From: Contact Centre (CRM) <contact@ribblevalley.gov.uk>
Sent: 11 May 2026 19:08
To: Planning
Subject: Planning Application Comments - 3/2026/0286 FS-Case-836849687

Planning Application Reference No.: 3/2026/0286

Address of Development: 53 Knowsley Road

Dear Ms Robinson
Planning Application 3/2026/0286
Proposed construction of a detached garage in the front garden.

2 Proposed East Elevation - Street Scene
1:100

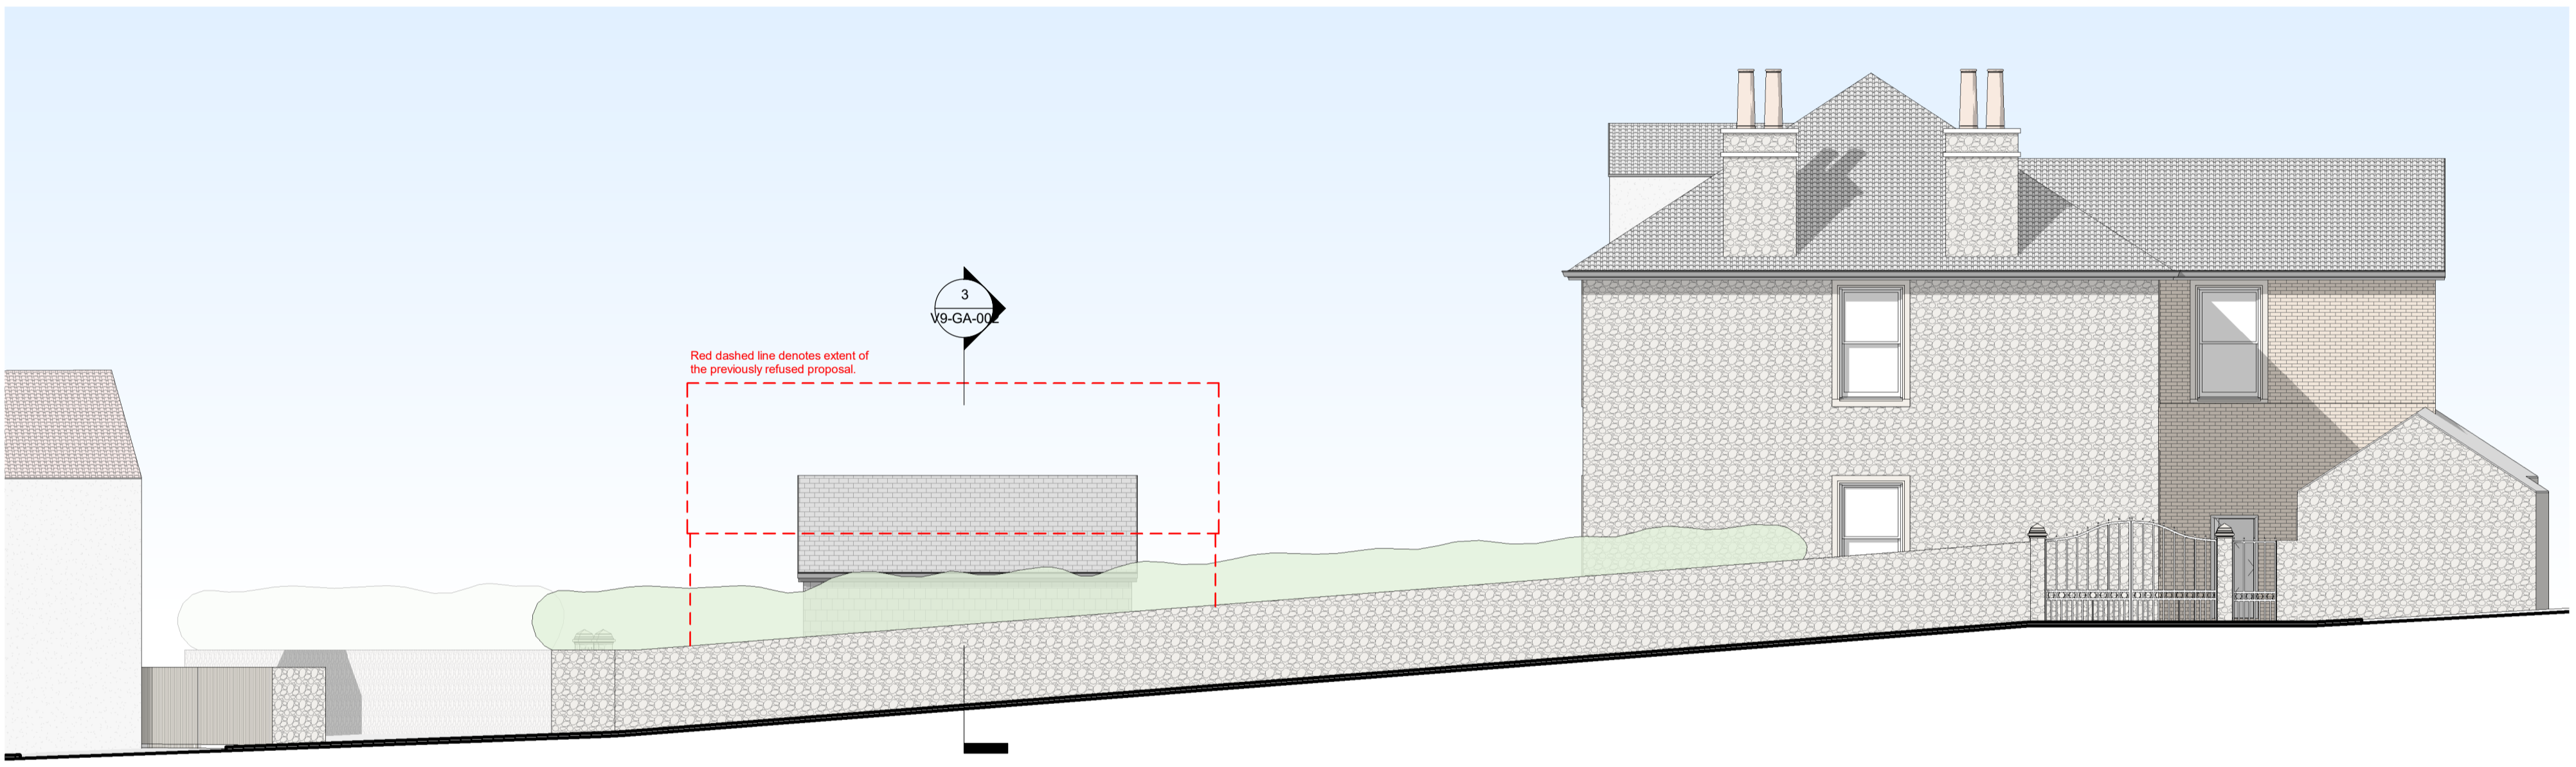
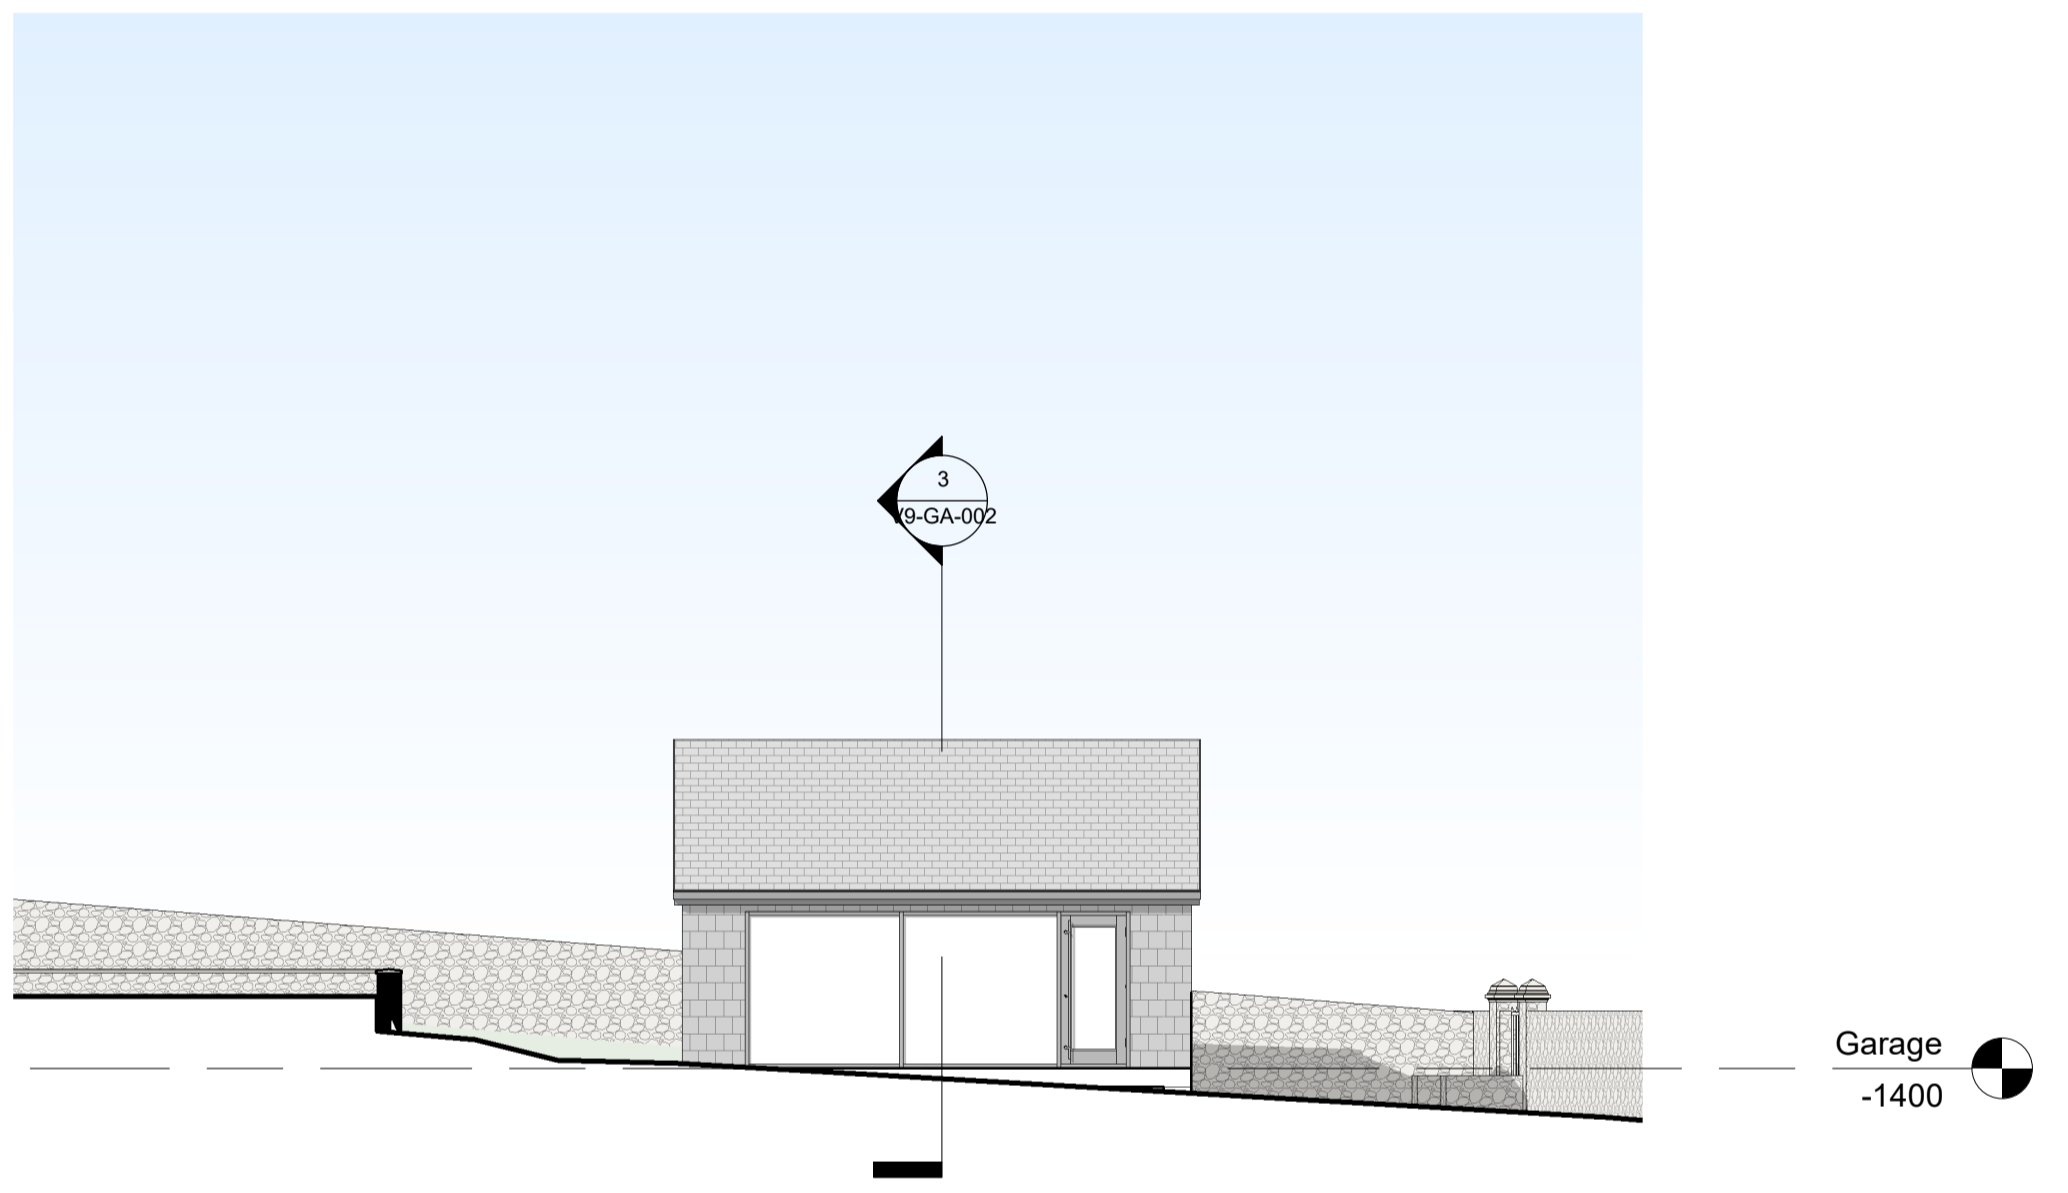
Comments: Whilst the revised plans for a double garage have been reduced in size from the previous application, they still include large glazing and a paved area, with a glass balustrade overlooking the garden.

This seems to indicate that the "garage" will not be used primarily for parking cars, but as a leisure facility.

The proposed garage will be built in the front garden of 53 Knowsley Road, running parallel to the roadside and very close to the boundary and footpath. All garages on Knowsley Road are set back from the roadside, none run parallel to the road. The siting of the proposed garage will adversely affect the street scene as the openness of the area will be lost. This is the only green and open space on Knowsley Road which will be totally ruined by the proposed garage. The property commands an extremely prominent position therefore the proposed garage within a front garden setting would have a detrimental impact on the character of the area. Due to the sloping site the appearance of the proposed building would be even more visually harmful to the surroundings. The large patio doors leading onto a raised terrace with a glass balcony do not appear to be compatible with a garage and would be totally out of character with the main property. Are these required if the sole use of the proposed building is just a garage. Because of [REDACTED] our [REDACTED] from [REDACTED] would be of a building 6 metres in length (internal) and approximately 4.35 metres high (5.28 metres high viewed from the south east corner of the site). This would be positioned [REDACTED] and not adequately screened by the slow growing yew hedge.
